Recommendation Report for Prior Notification

REF NO: LU/57/25/PD

LOCATION: 51 Pier Road  
Littlehampton  
BN17 5LP

PROPOSAL: Prior notification under Schedule 2, Part 3, Class MA for the change of use of part of building on ground floor from restaurant (Class E) to dwelling house (Class C3).

North Elevation - Existing

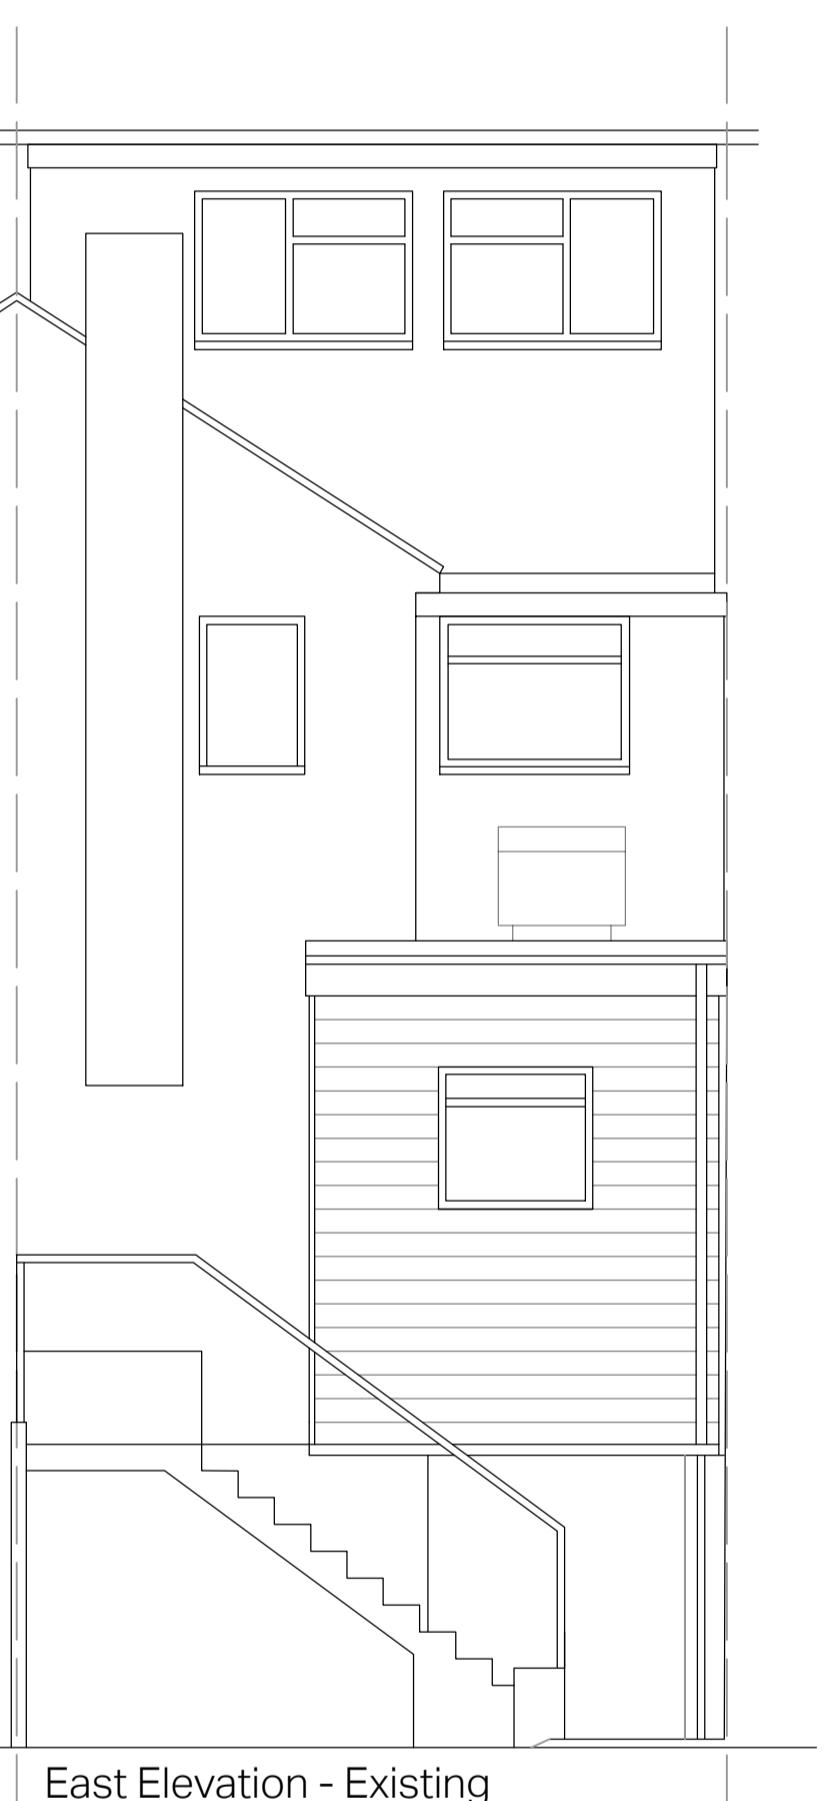
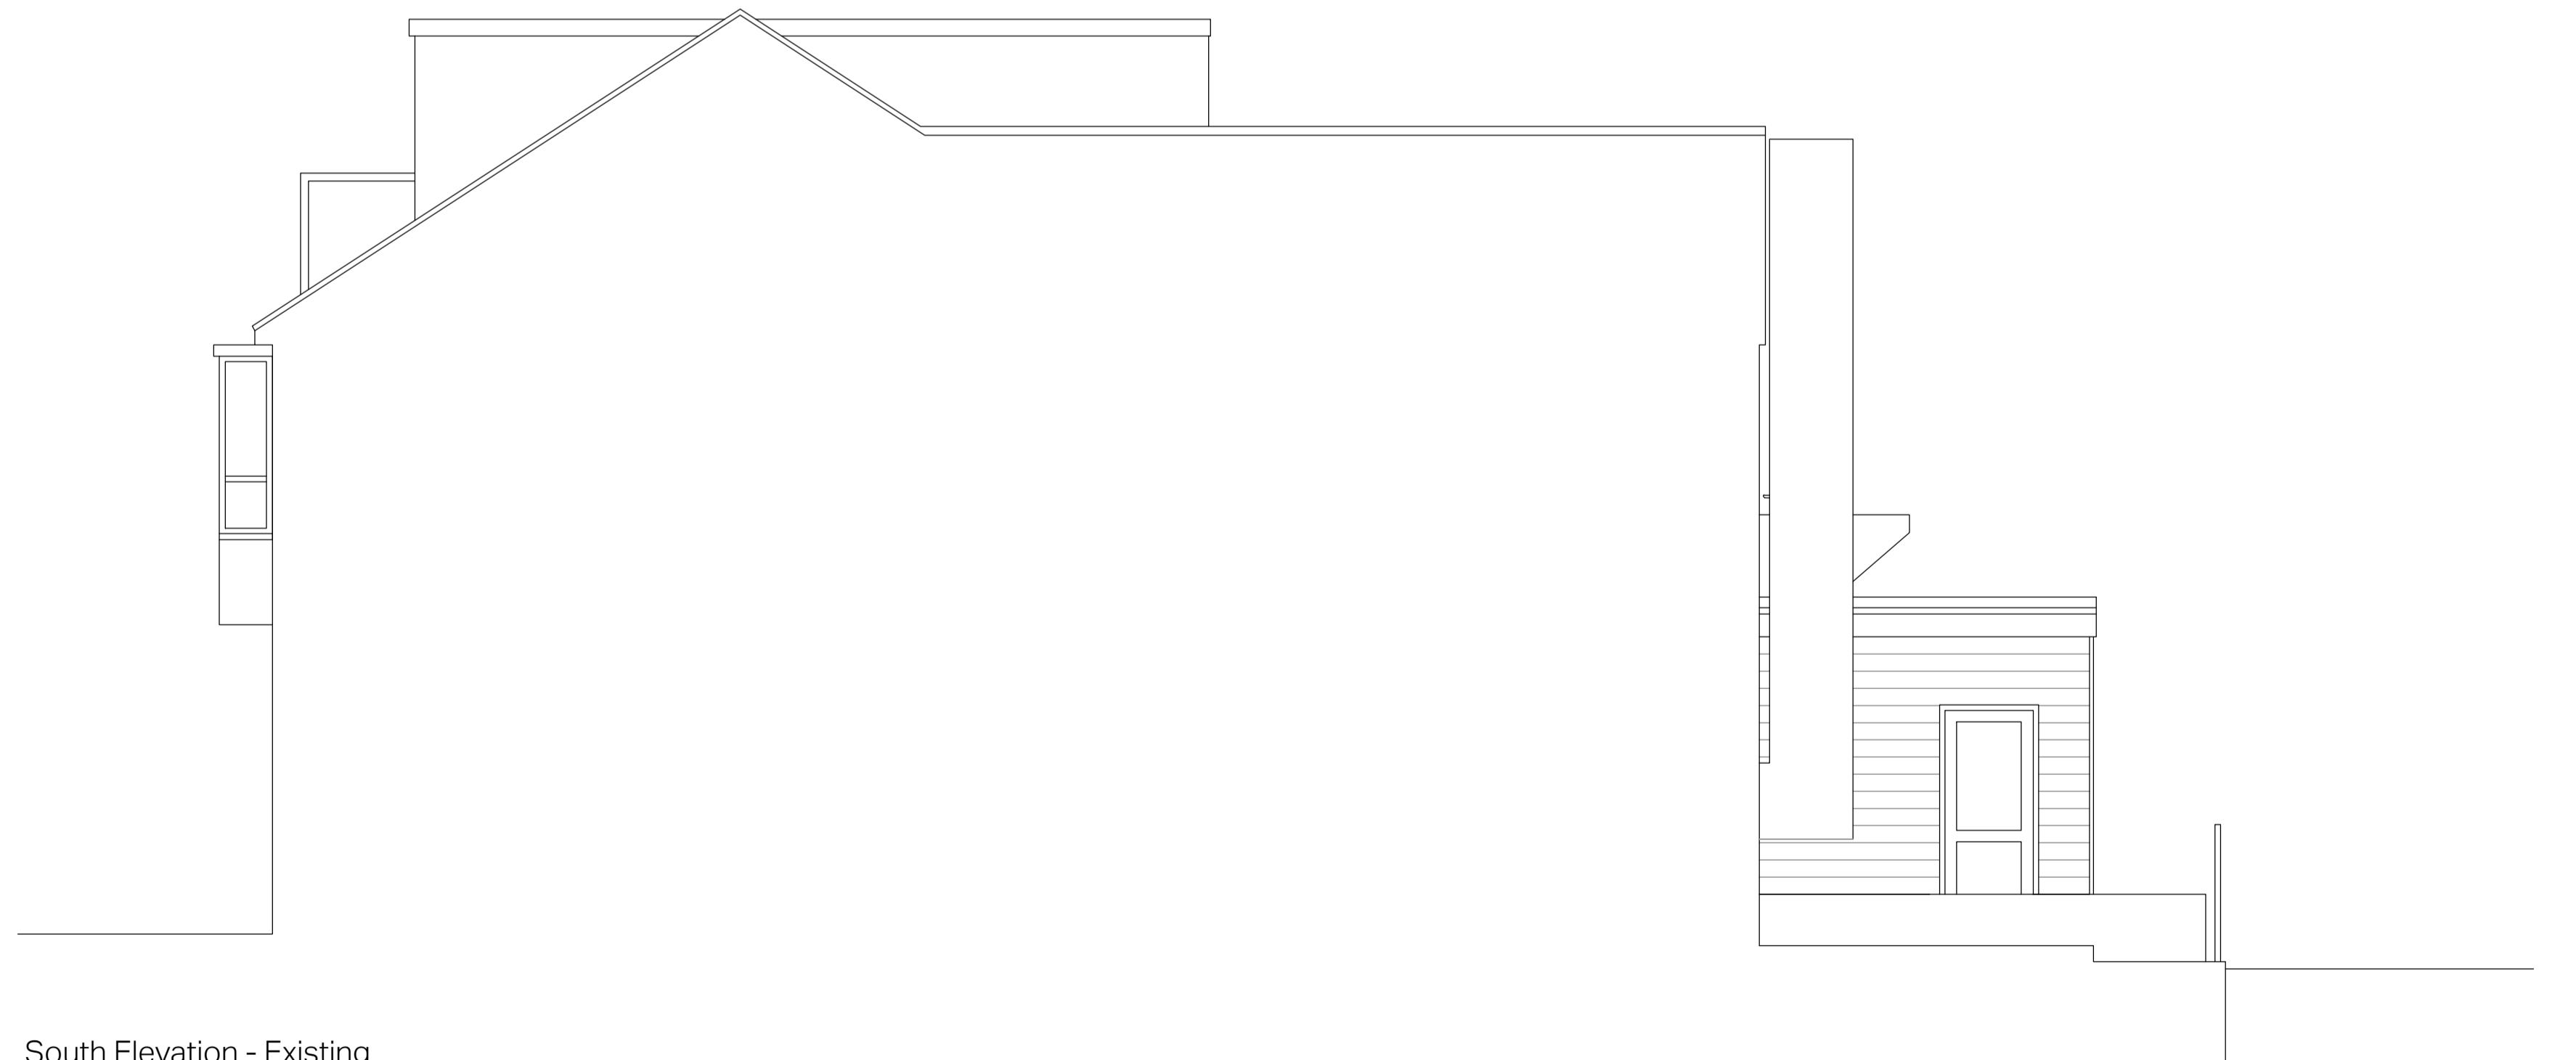
It is noted that the elevations involve the relocation of a rear access door to the rear elevation of the building. Whilst this has not been applied for as part of this application, consideration as to whether the alteration constitutes development under Section 55 of the Town and Country Planning Act 1990 should still be given as part of the consideration.

The proposed plans indicate the removal of some plant/ventilation equipment which would not require development consent, but also the relocation of a rear access door from the southern elevation to the east elevation and by approx. 2m. The Local Planning Authority are satisfied that in this context, the relocation of the access door would not materially alter the appearance of the building and would not constitute development in accordance with Section 55 of the Town and Country Planning Act 1990.

Ground Floor Plan - Proposed

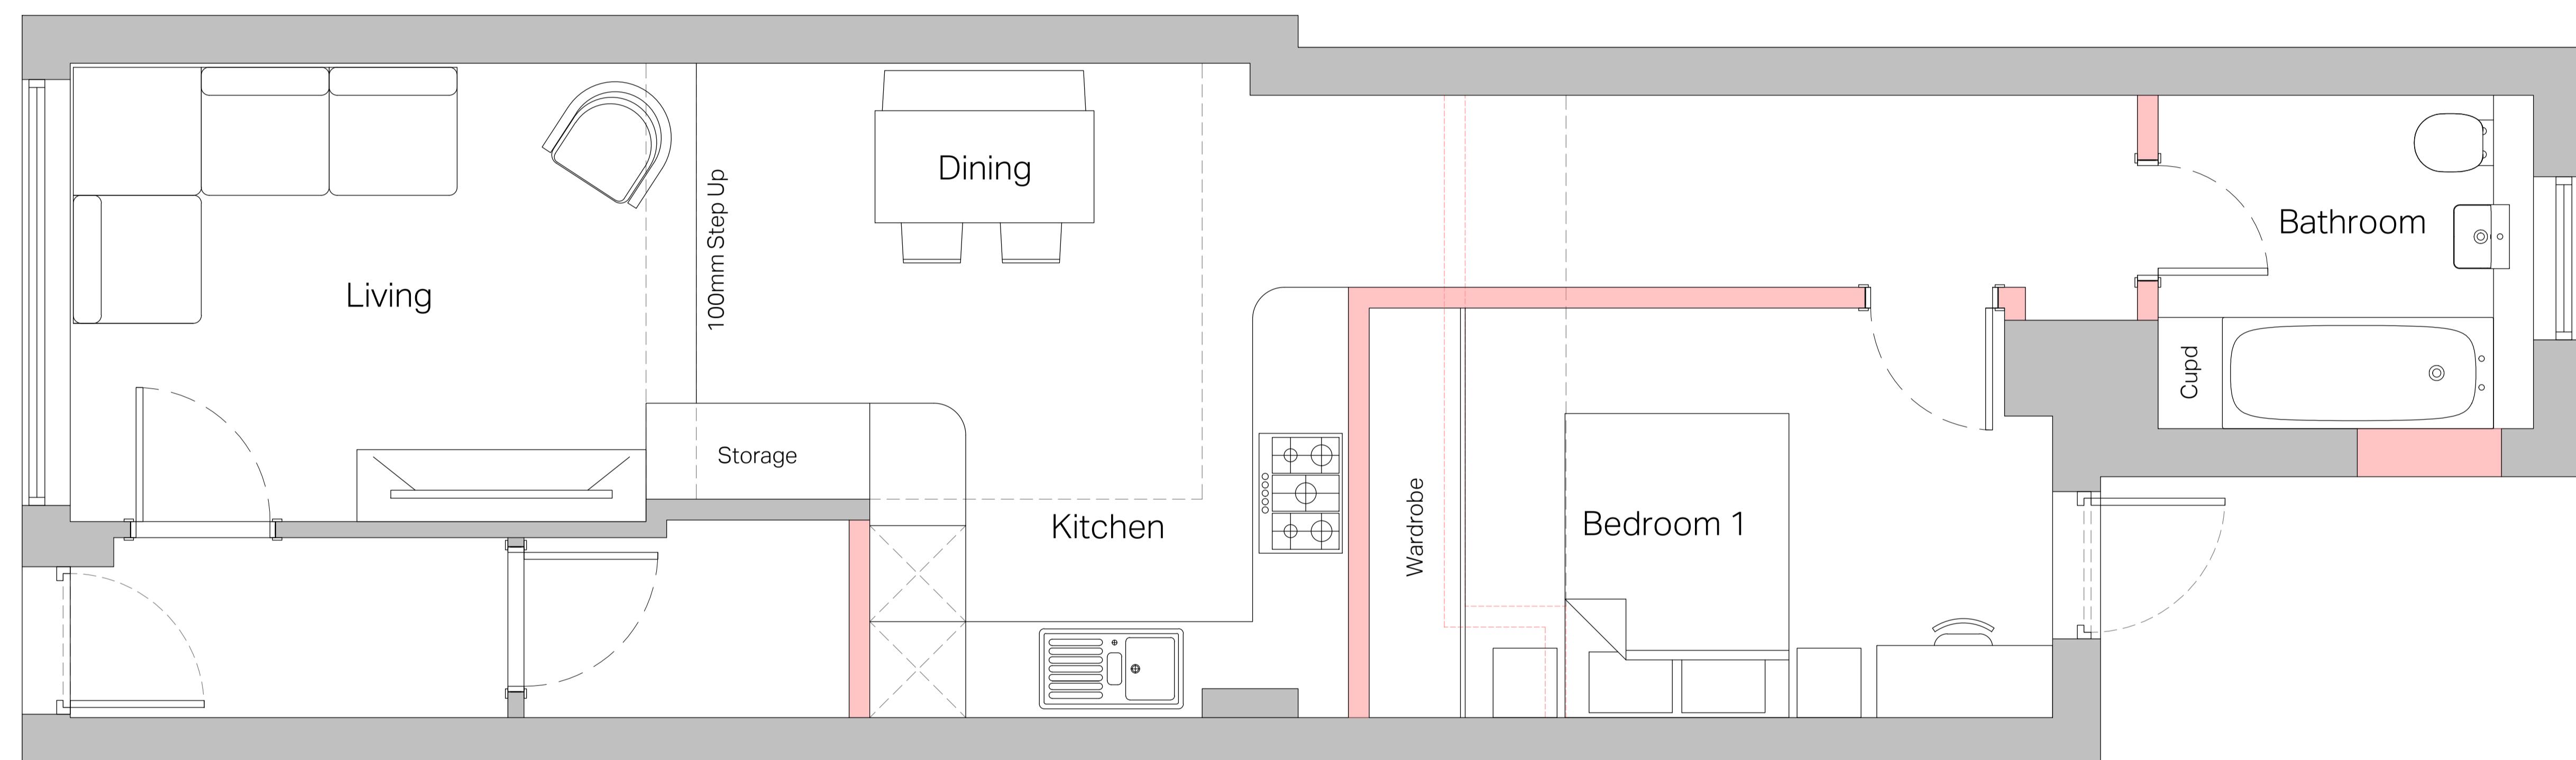
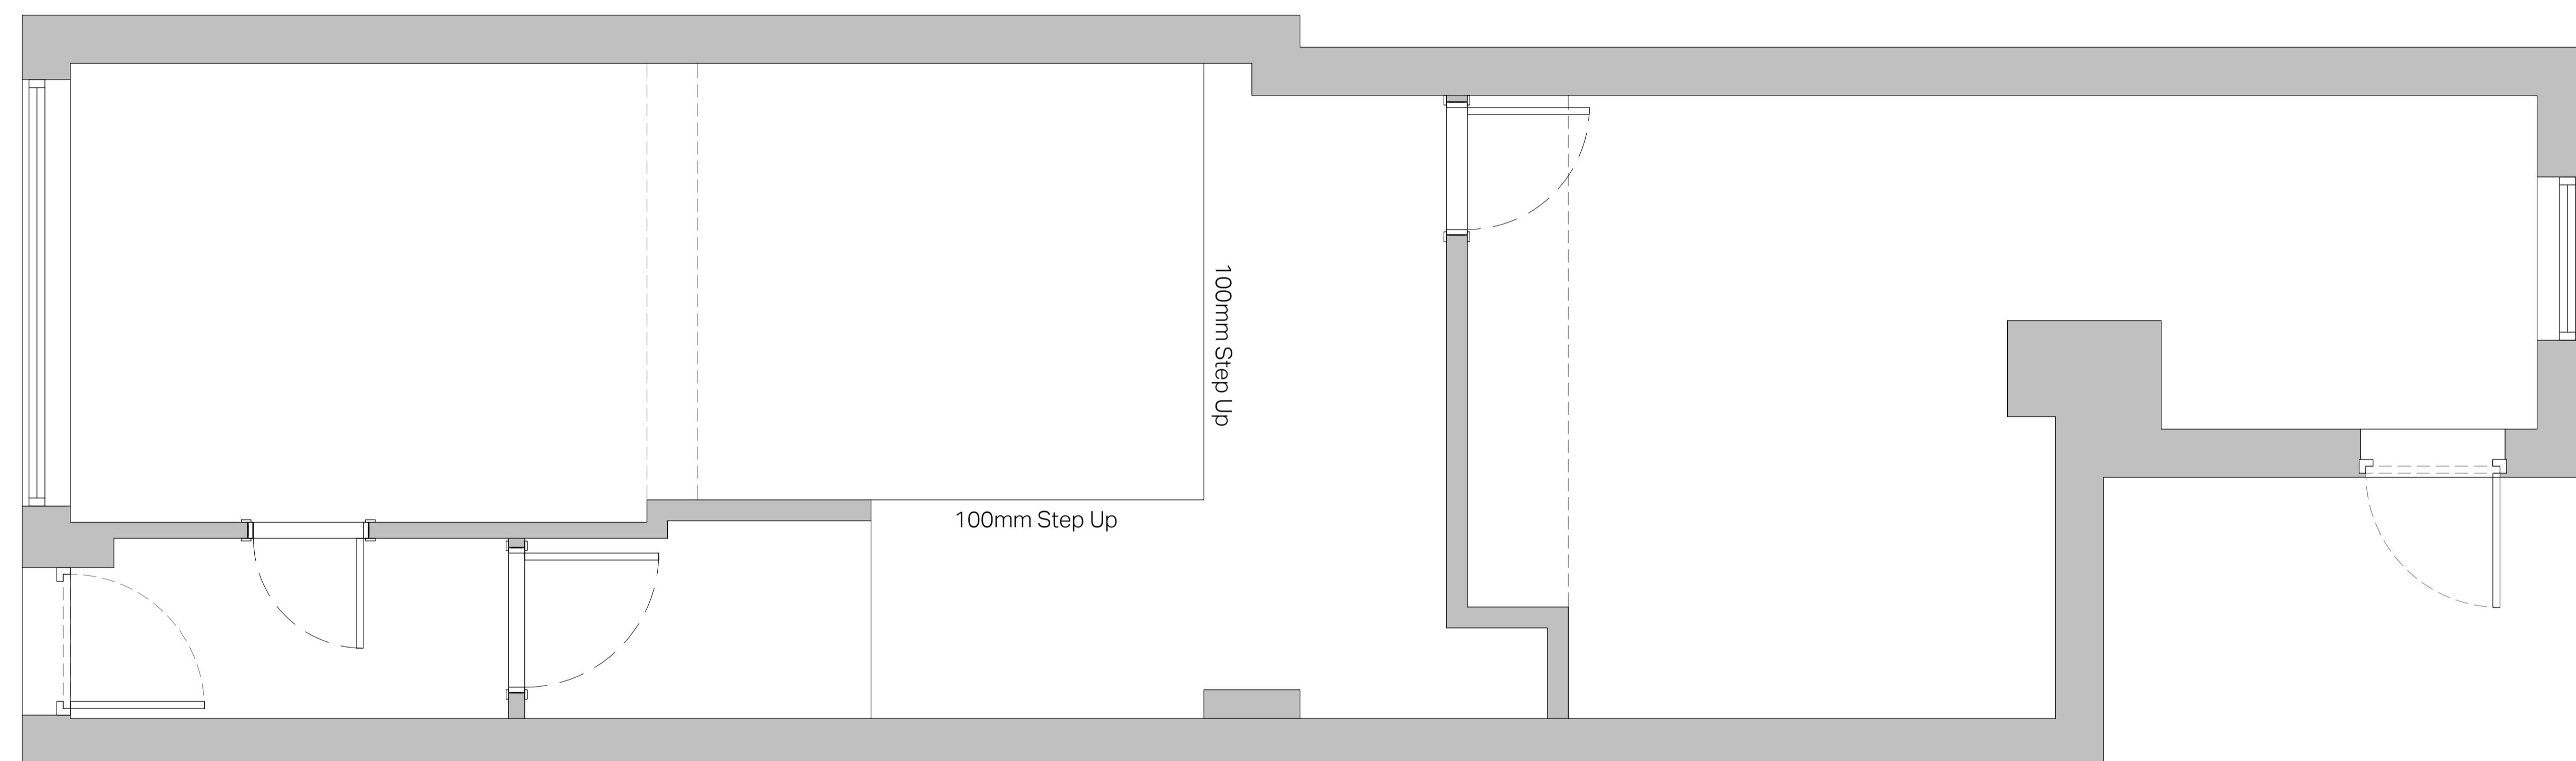
The proposed living room area would benefit from sufficient light through what is the existing shop frontage window. The bedroom to the rear would benefit from sufficient light through the rear glazed access door that is to serve the bedroom.

The proposed unit is single storey and provides 1 No. bedroom. The dwelling would have an internal floorspace of just over 49.2sqm, which is compliant with the minimum internal floor space required for such a dwelling. The bedroom is also of sufficient width and area.
